Your Reference: **FG/59/19/HH**

Development: Erection of Single Storey extension to East elevation and First Floor extension

Location: Pied at Terre, Ferring Street, Ferring

Proposed First Floor Plan

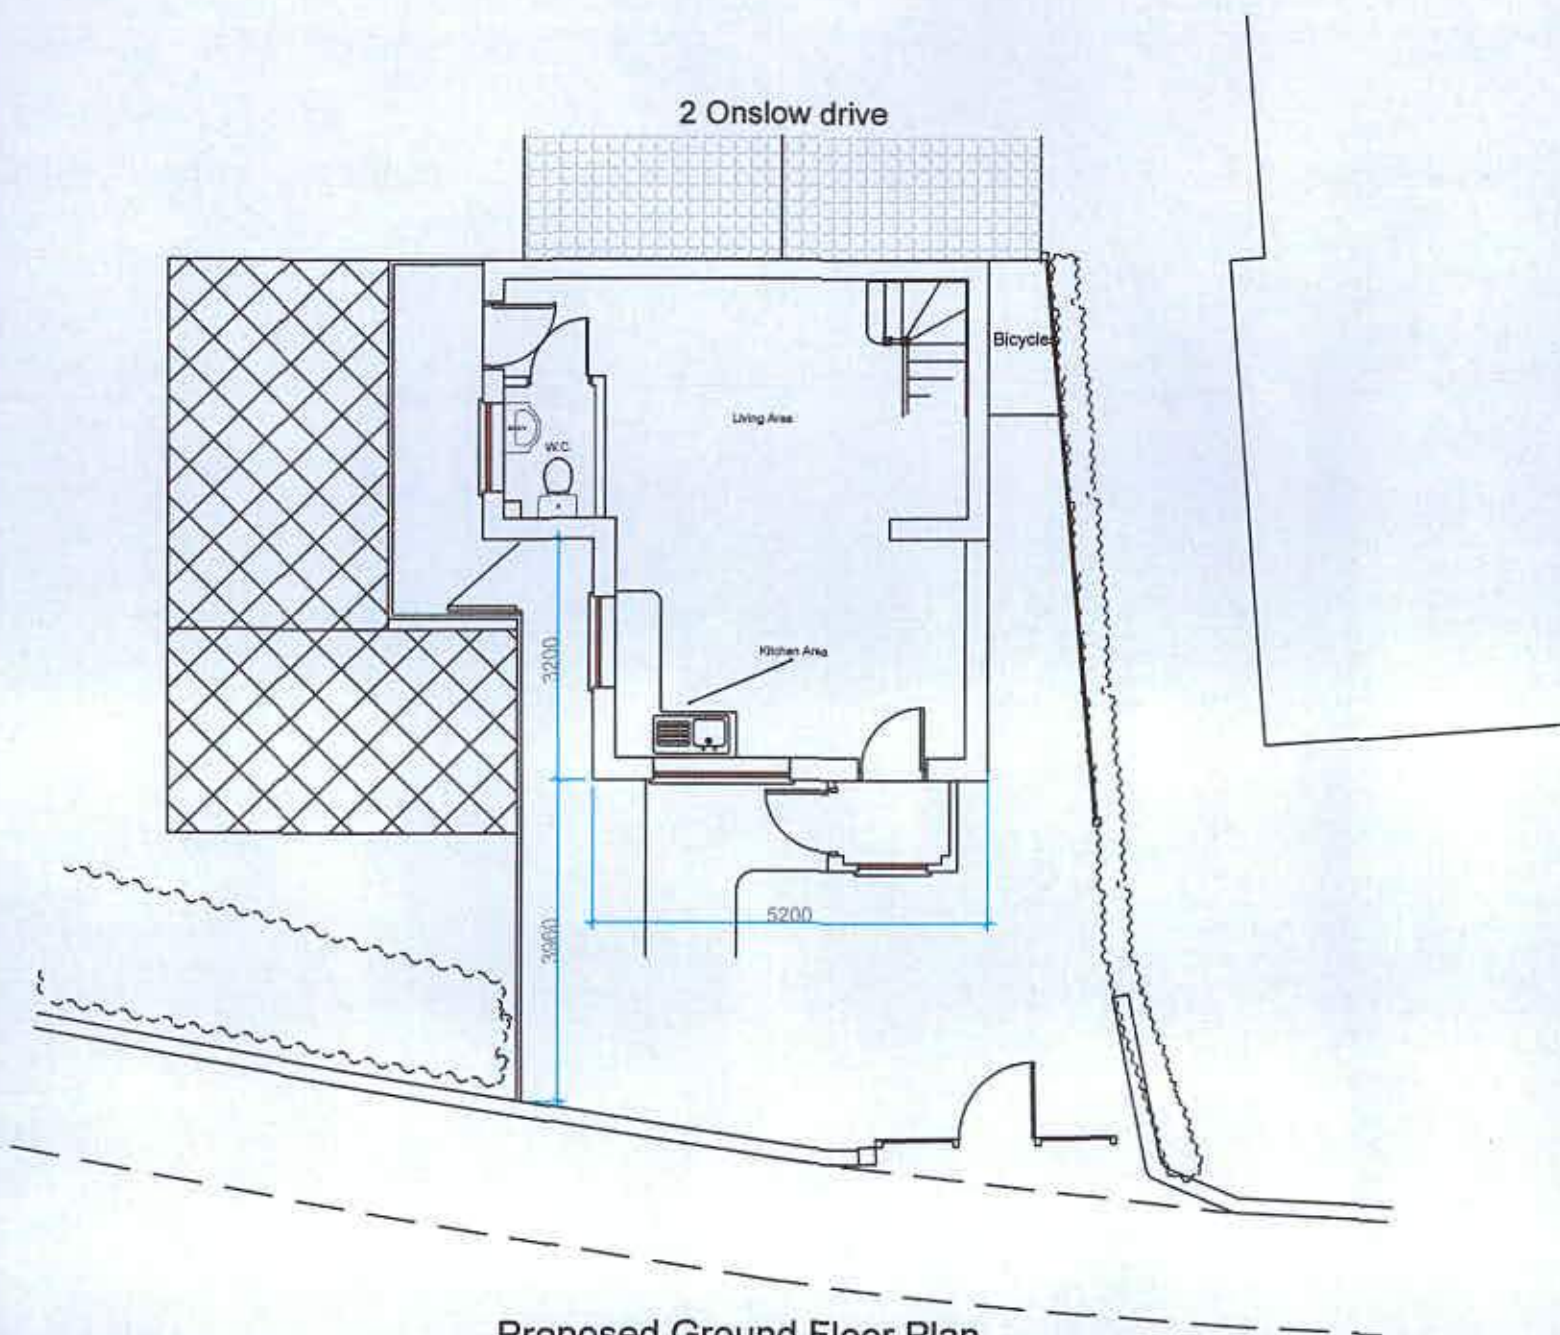
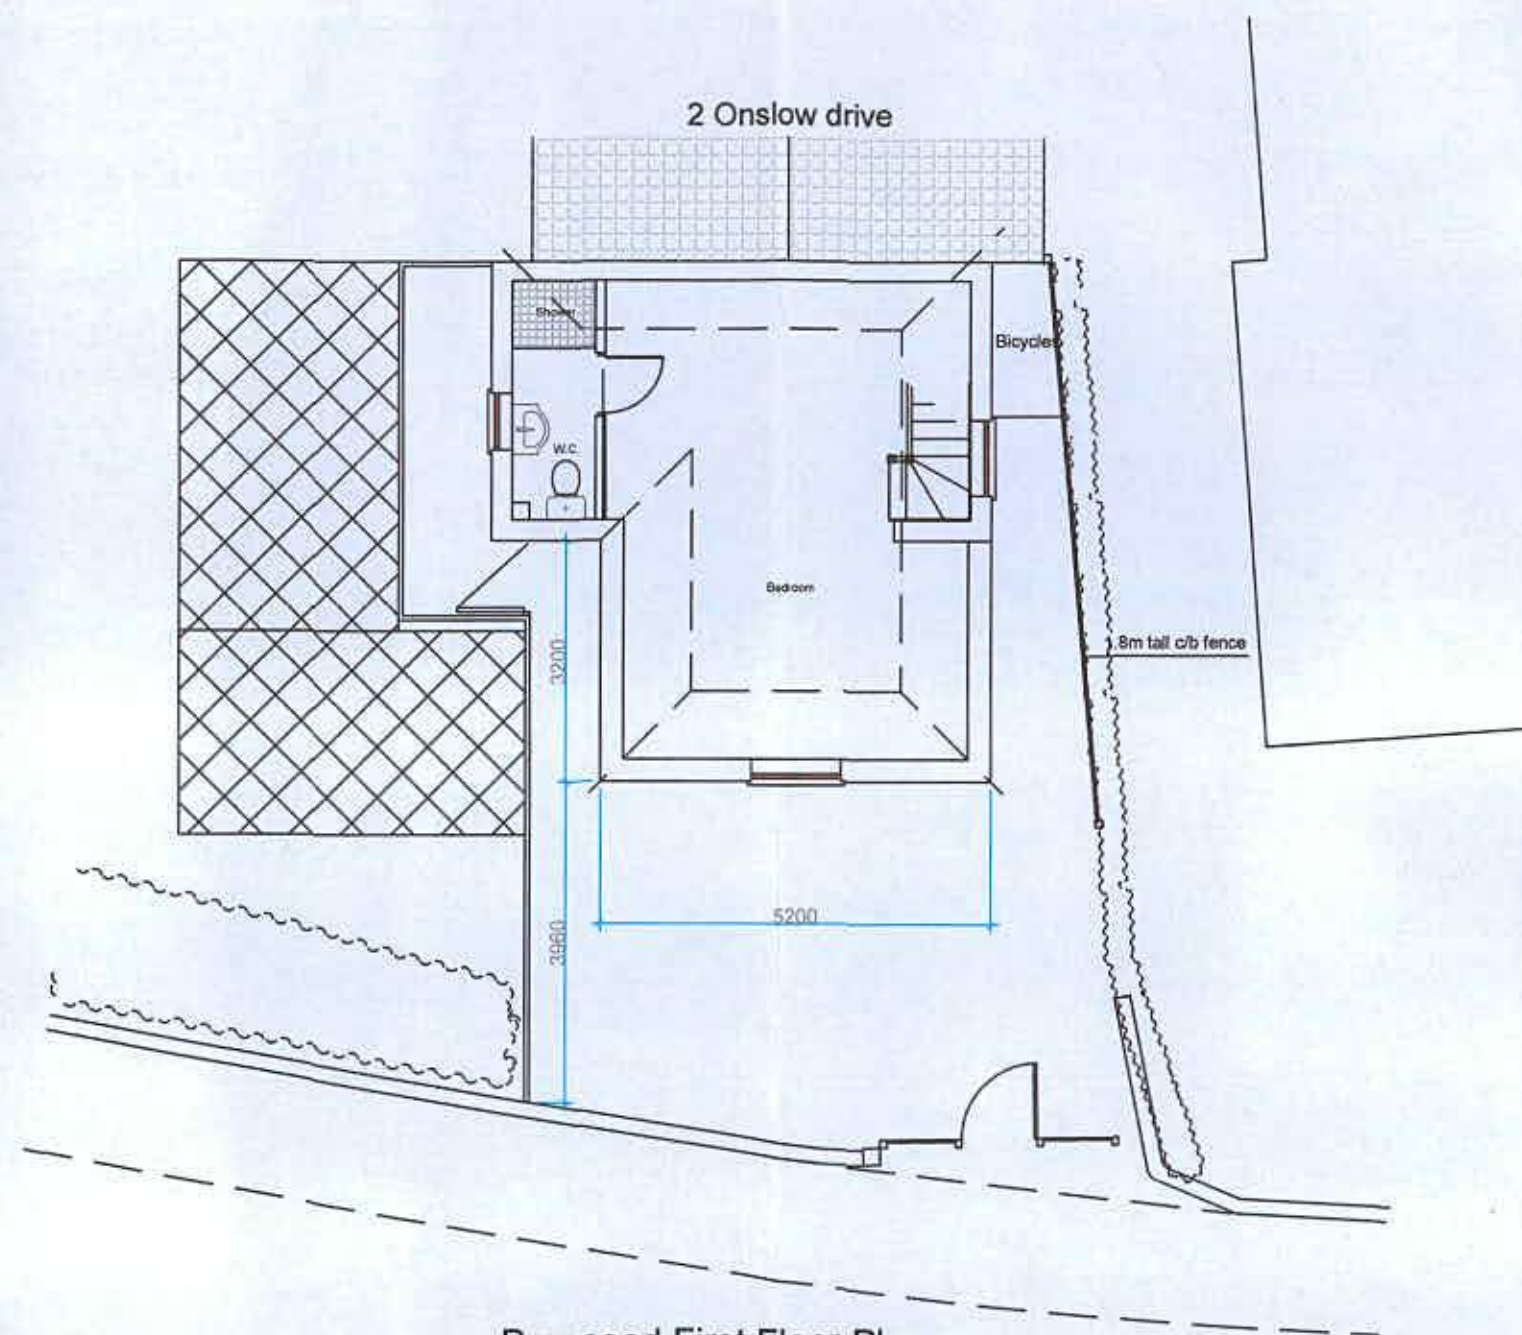
I wish to object to the above proposed development because I am concerned that the extended first floor will:

1. Cause loss of sunlight to my south facing window creating a darker kitchen and bathroom
2. Present a close blank wall from my window as the immediate view less than four metres from my south facing window rather than onto the unoppressive open forecourt view that currently exists
3. Cause a dominating and oppressive effect on my home
4. The block and roof plan shows the front roof line in line with the front of Pump Court and does not show the porch that projects in front of the building line, the proposed plans indicate the front wall in front of the building line
5. The trees and shrubs along the boundary between the two properties will be deprived of sunlight
